Re: Gunlake Quarry Extension Project (SSD_7090)

I refer to an email from Megan Dawson of the Department of Planning & Environment (DPE) dated 26 September 2016 regarding the Response to Submissions Report (RTS) for the proposed Gunlake Quarry Extension Project (SSD_7090). The email requested the Environment Protection Authority (EPA) review the RTS report and provide comment.

Figure 2-4: Surrounding sensitive receptor and monitoring locations

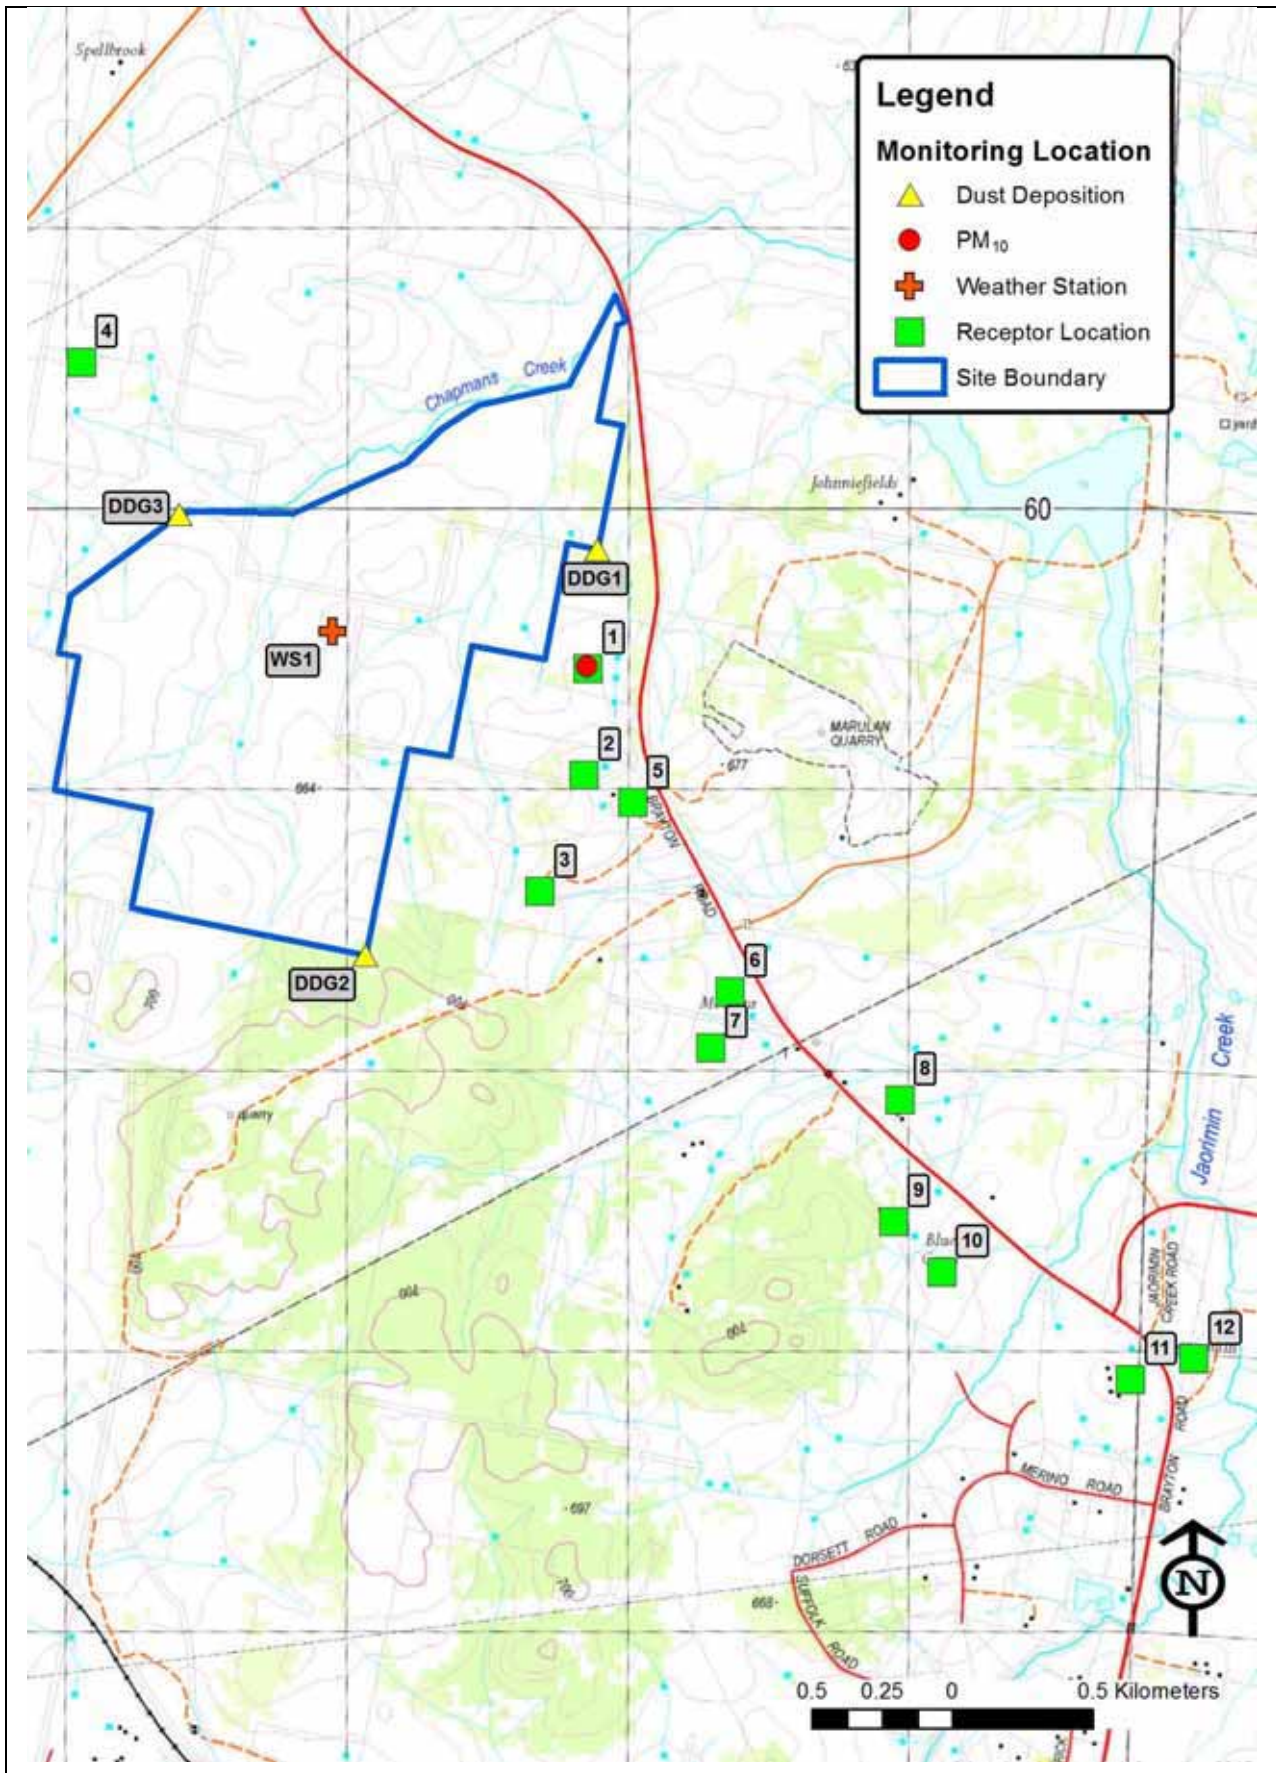
The proponent disagrees with the EPA's suggestion of the installation of additional High Volume Air Samplers (HVAS) at Receptors R4 and R6. The EPA requests DPE consider requiring the placement of an additional HVAS at Receptor 4 (now owned by Gunlake Quarries) which is located generally to the west of the Gunlake Quarry and (in the prevailing westerly winds) would generally provide a good indication of ambient air quality upwind of the Quarry. This would allow the contribution of the quarry to dust generation to be more accurately estimated.

In the past, when the EPA has received dust complaints about the quarry, it has been difficult to establish the contribution of the quarry to ambient dust levels with the only HVAS located downwind of the quarry, at Receptor R1 (in the prevailing westerly winds).

In addition, the EPA recommends the placement of an additional HVAS at Receptor R6, which is located generally to the south-east of the Quarry and is not associated with the quarry operations, unlike R1 and R4. This would provide a good indication of quarry operational impacts on private lands. It would also

provide a more reliable indicator of dust impacts as the quarry pit moves southwards over the coming years and receptor R1 becomes located progressively more northerly of the quarry pit.
